Our Ref: 24/01308/LBC
Your Ref: 21 High Green, Great Shelford

**South Cambridgeshire District Council
Application for Listed Building Consent**

Proposal: Single Storey Front Extension (Resubmission of 23/01064/LBC).

Site address: 21 High Green Great Shelford Cambridgeshire CB22 5EG

DRAWN	DATE
BSc	14.02.23
SCALE @ A3	DRG. NO.
1:500	A80-B

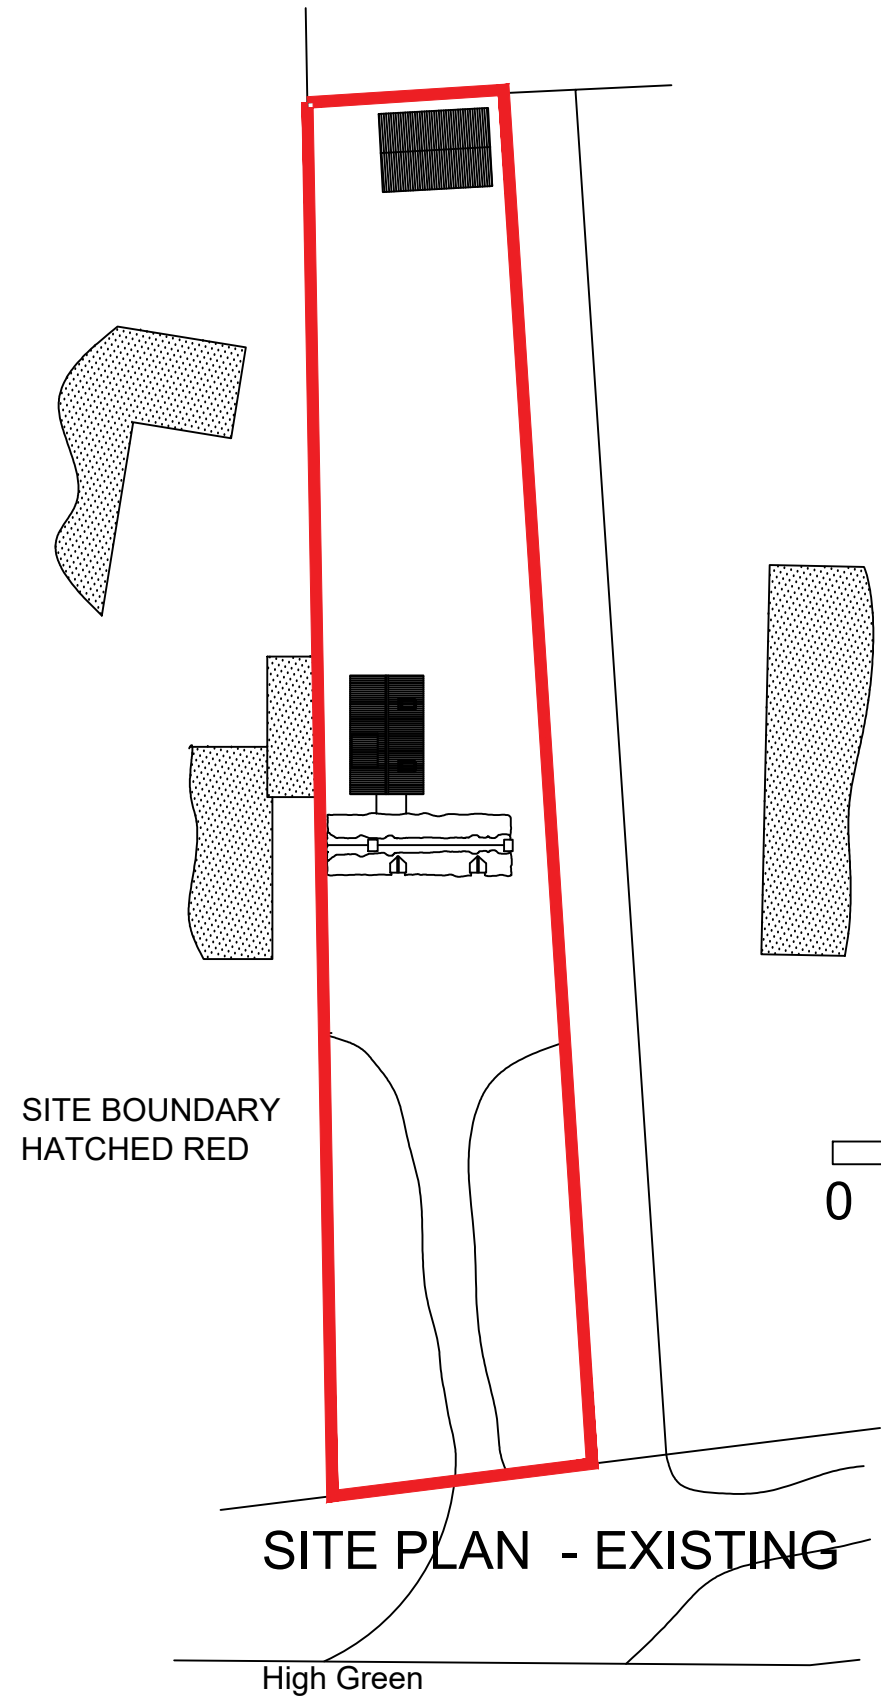
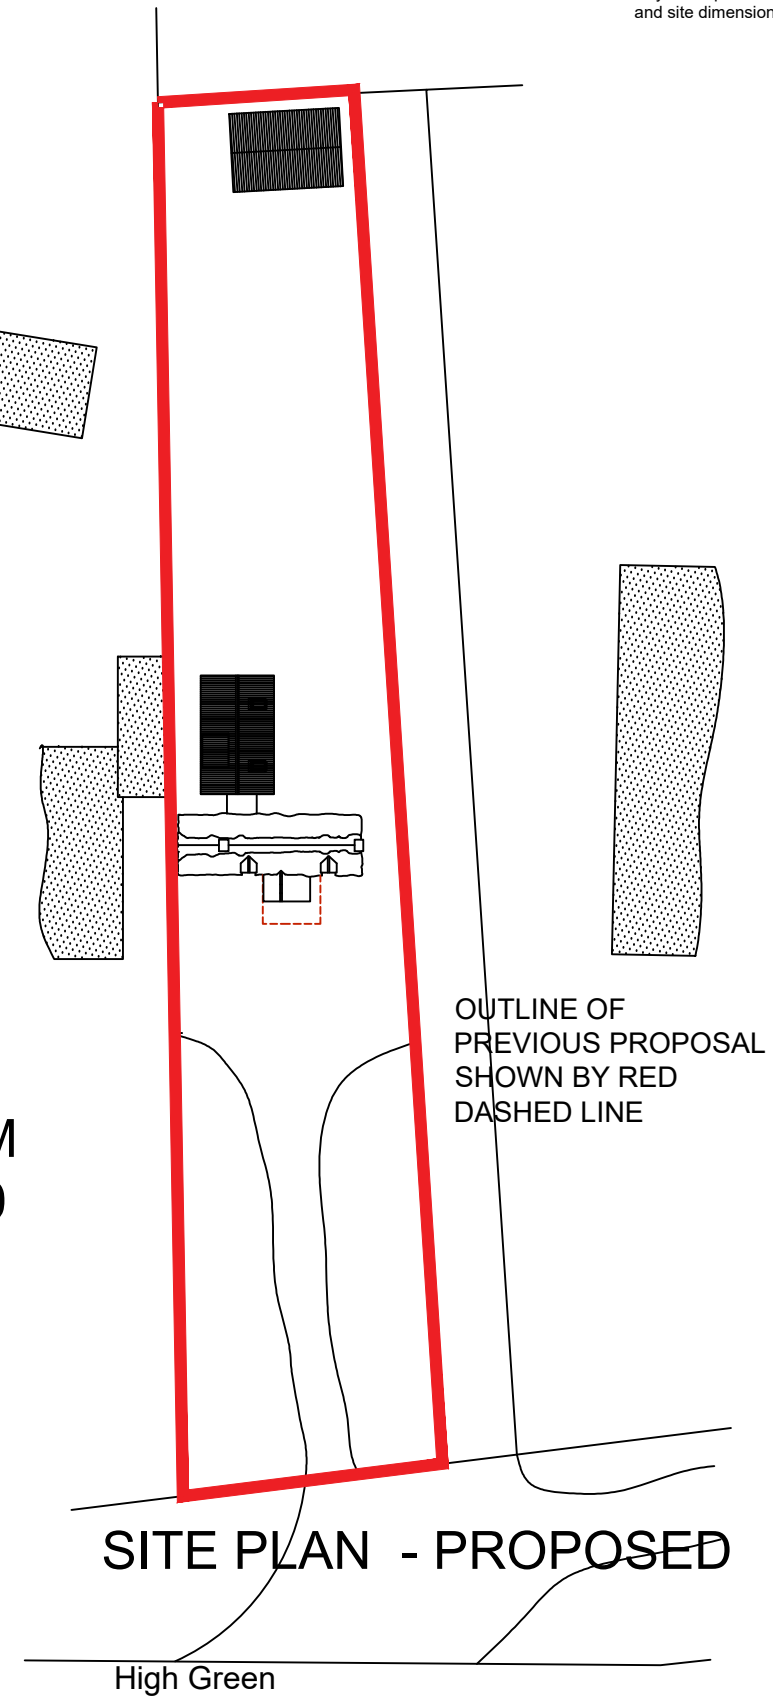
1. East and West elevations are shown differently on drawing numbers A101, A90 and A91A. Please amend and resubmit.
2. Please confirm that you are agreeable to the proposal being amended to: 'Single Storey Front Extension (Resubmission of 23/01064/LBC)'.
3. Drawings A80A - Site Plan proposed and A101 - proposed elevations show development to the rear of the property that isn't mentioned in the proposal. Can you please either add to the proposal or remove from the drawings if not intended to be applied for.
